LSC TRANSPORTATION CONSULTANTS, INC.
2504 East Pikes Peak Avenue, Suite 304
Colorado Springs, CO 80909
(719) 633-2868
FAX (719) 633-5430
E-mail: lsc@lsctrans.com
Website: <http://www.lsctrans.com>

May 27, 2020

RE: SH 94/Curtis Road
Traffic Impact Study
El Paso County, Colorado
LSC #204310

Figure 5

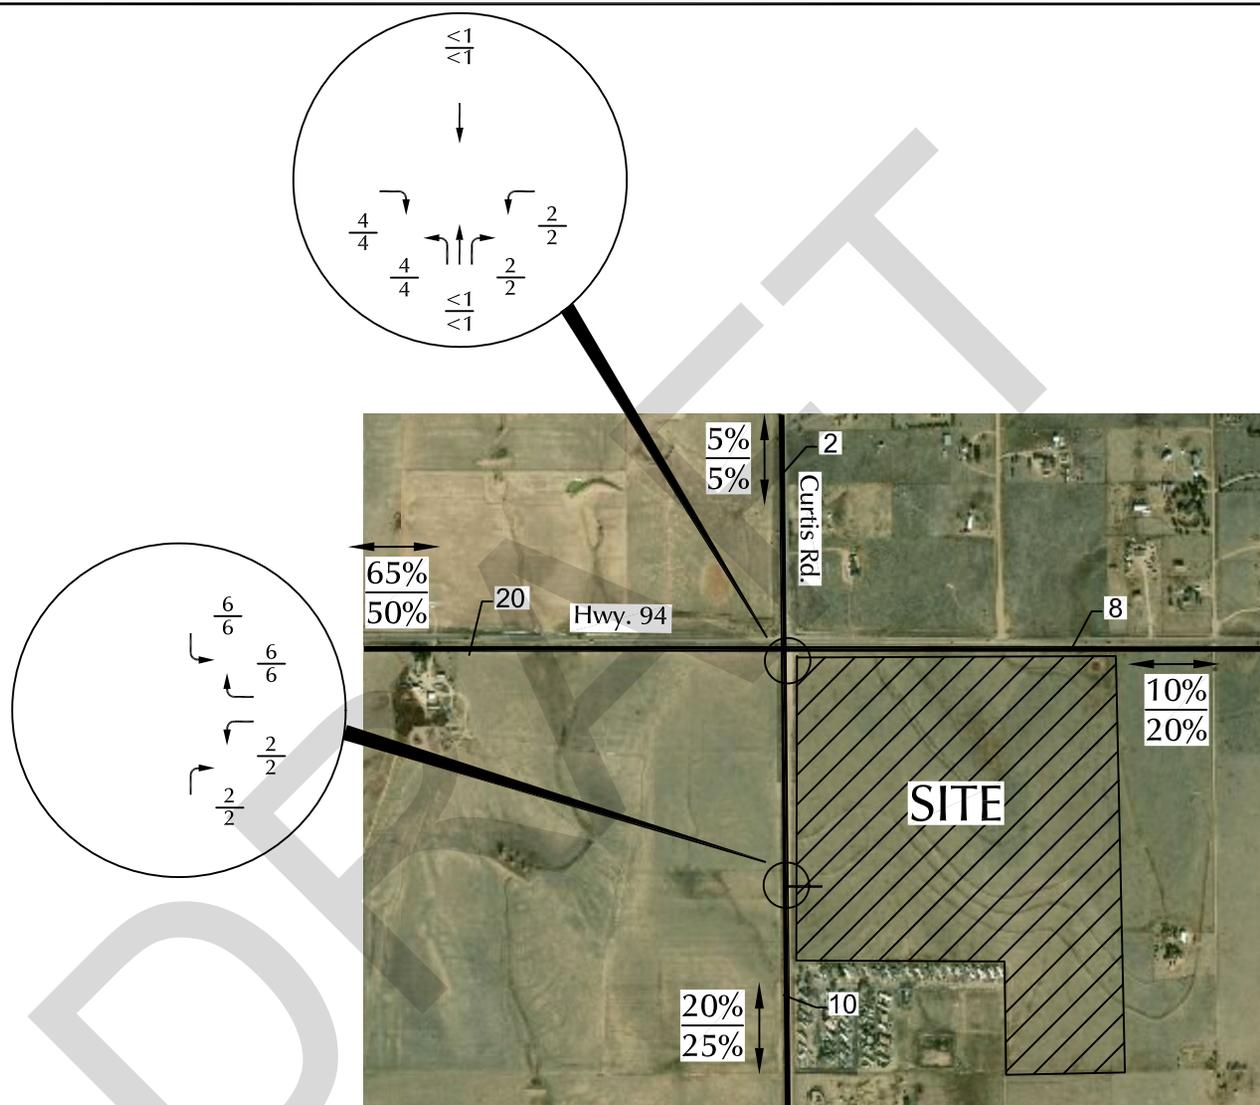
Please verify AM LOS after clarifying the volumes relative to what is reported in the LOS Reports. These volumes appear to correspond to the Short Term Background conditions report, if Long Term - EBT should be LOS C.

Figure 6
Phase 1 Trip Distribution
and Site-Generated Traffic

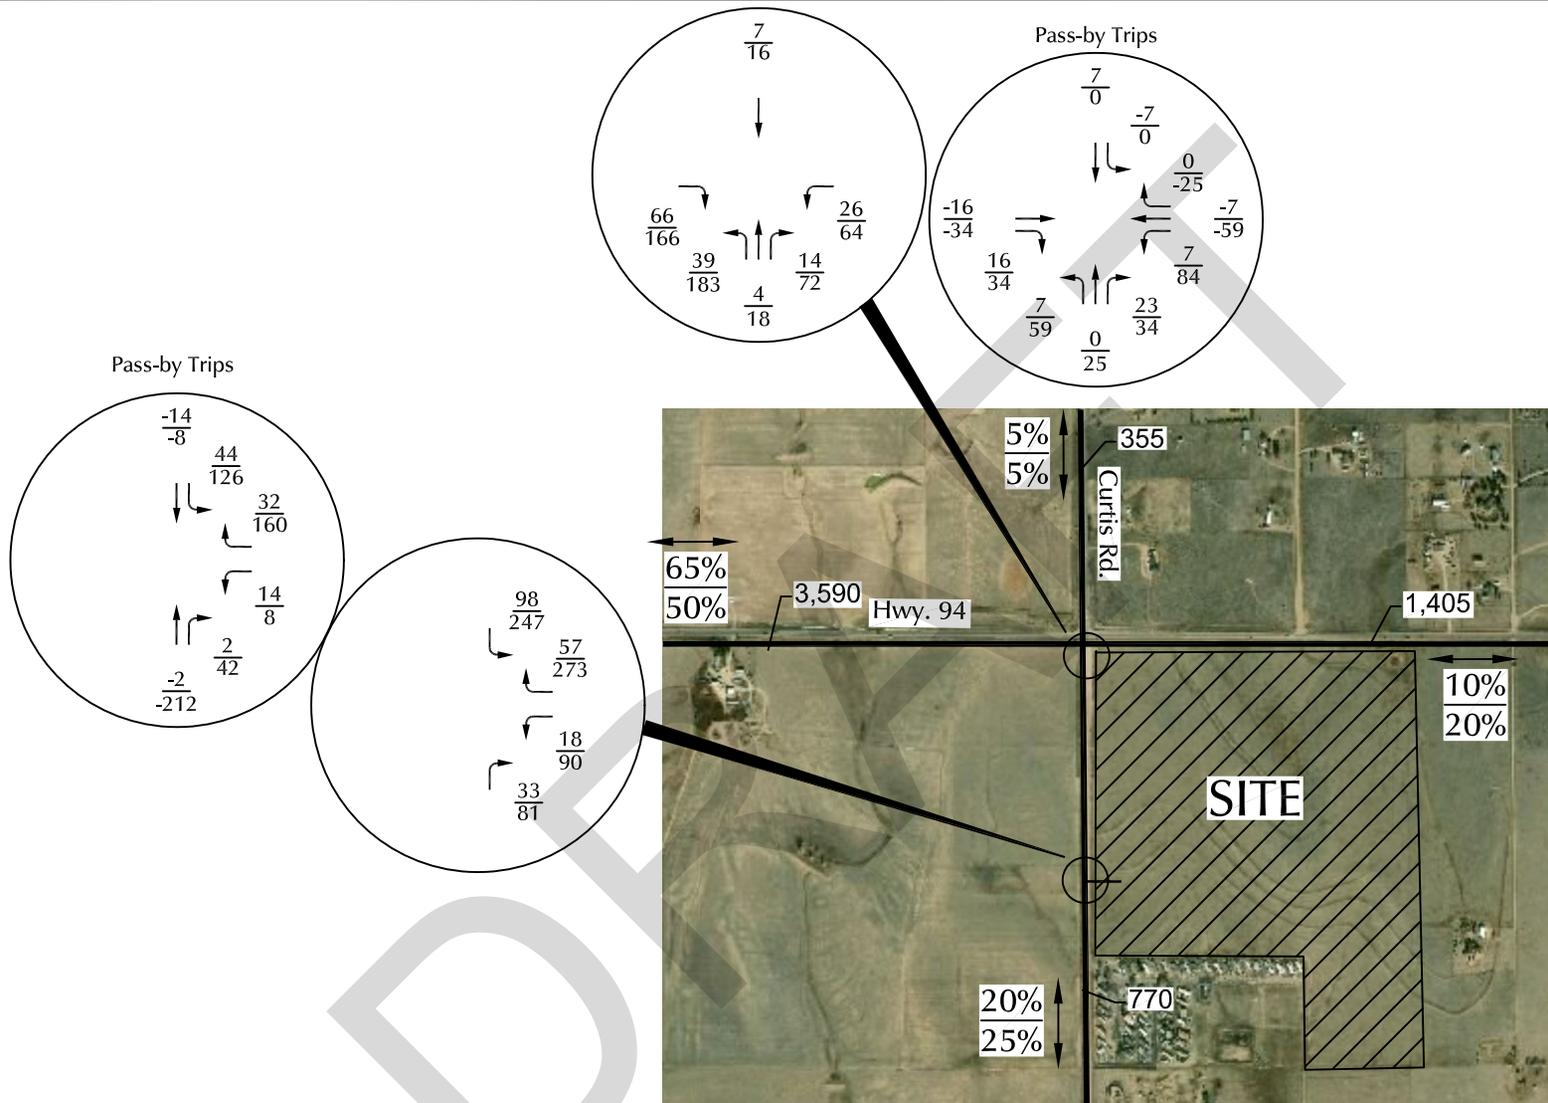
Phase 1 only includes the trucking business - removing the residential distribution is recommended for clarity

Figure 11
Buildout Long-Term (2040) Total Conditions

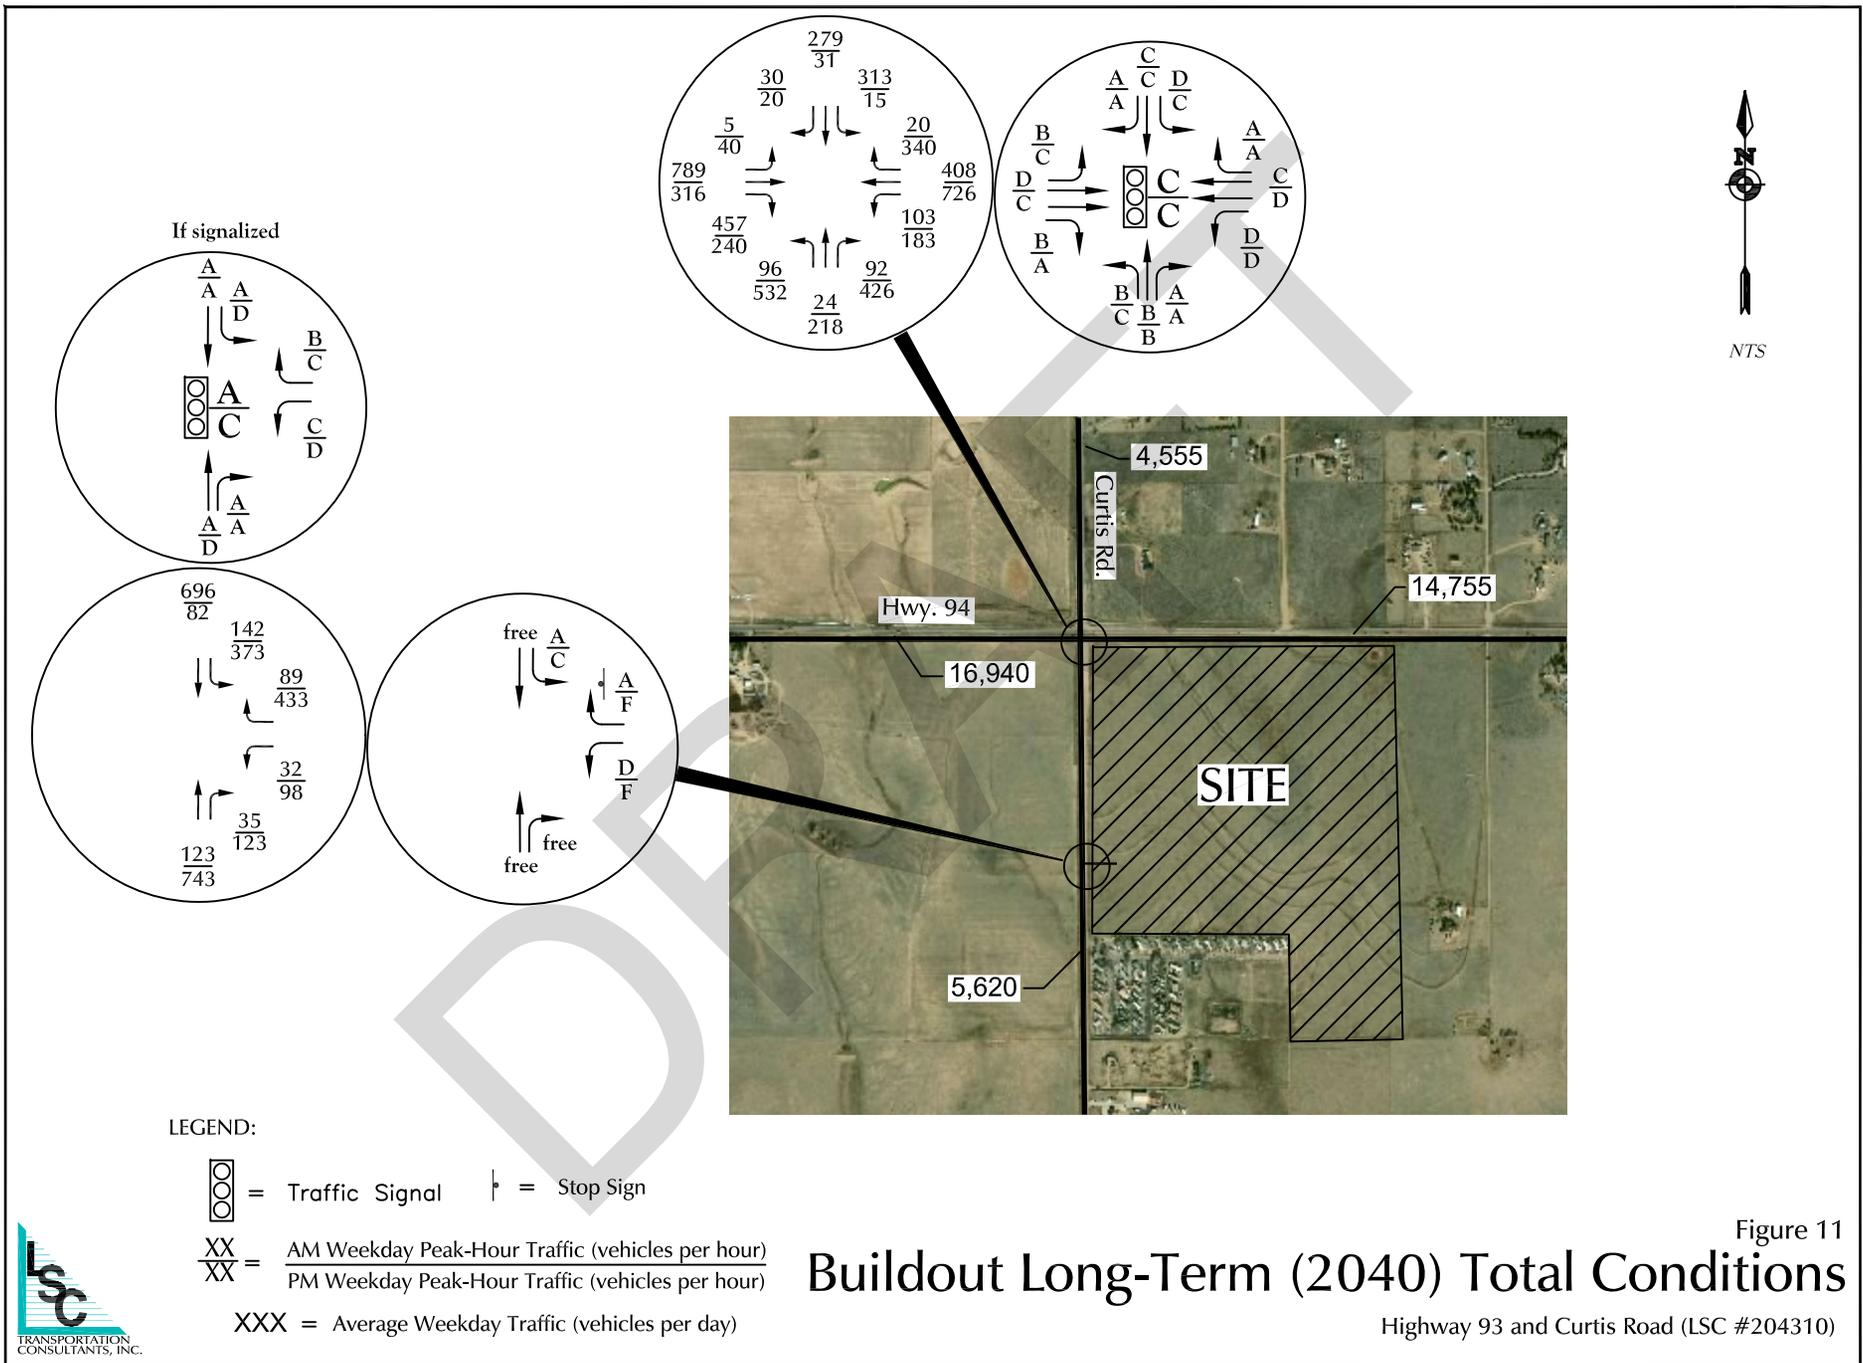
35?
